## 3. STREETS + BUILDING PLOTS

## **4. MASSING**

DEVELOPMENT APPLICATION
ILLUSTRATIVE SCHEME
SECTION C-C

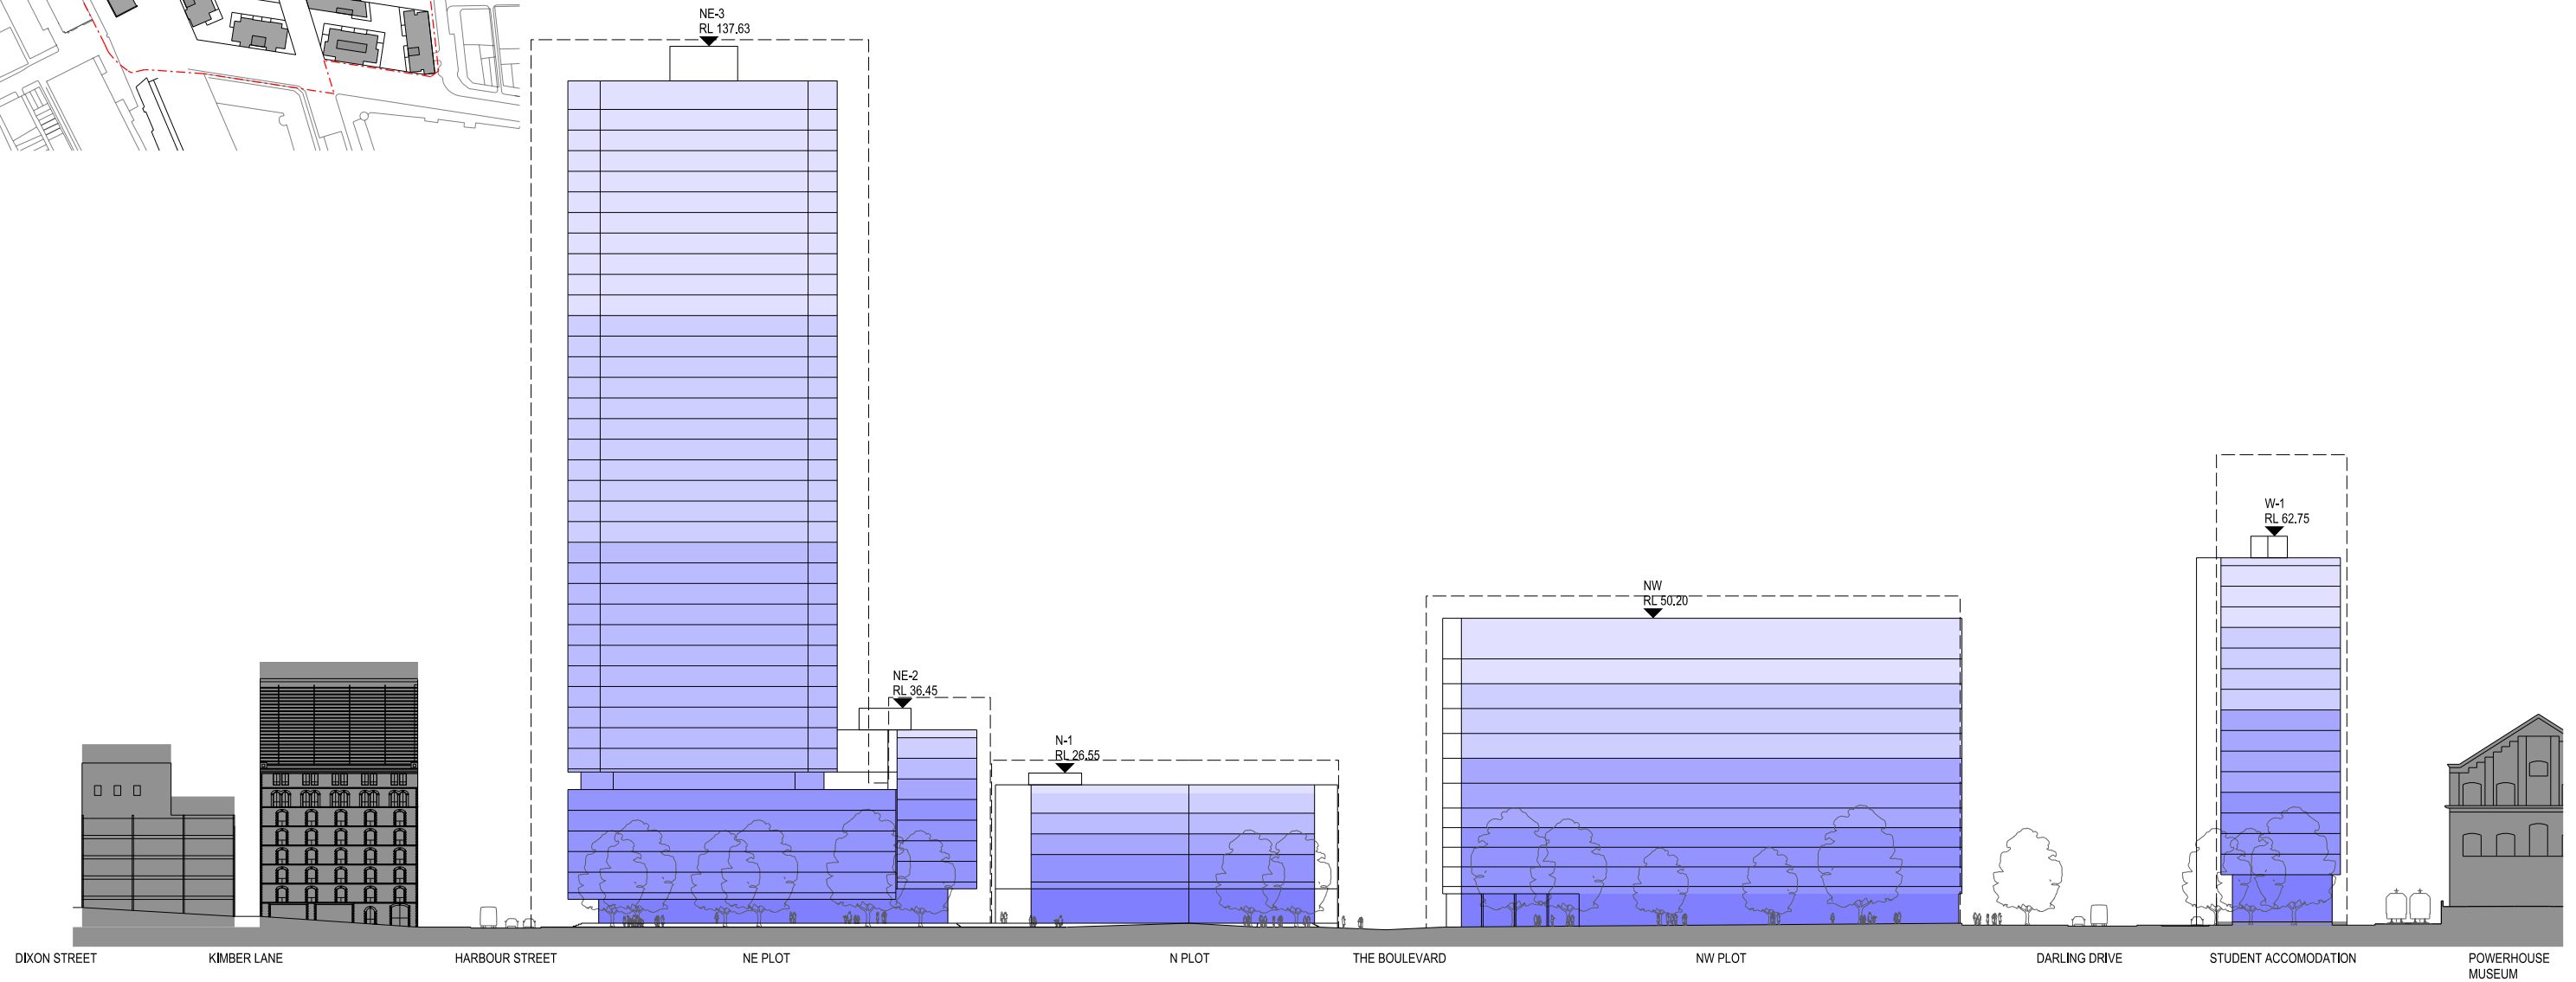
The podium heights surrounding the new square should be lowered in height with green roofs to improve winter sun access into the new square and potentially raised along the surrounding streets to rebalance floor area.

The north plot building should be reduced to four storeys to improve winter sun access into the new square.

The maximum building envelope proposed for the square edge allows for lift overruns and plant enclosure on the roof of these buildings.

The Illustrative Scheme indicates a parapet height lower than the current maximum building envelope with rooftop plant setback to minimise the visual impact.

This reduces overshadowing of The Boulevard and Haymarket Square and maximises the natural amenity of these new public spaces.

The N Plot building height needs to be sufficient to screen the Pier Street overpass from within Haymarket Square and to hold the western edge of the grand 20 metre Boulevard.
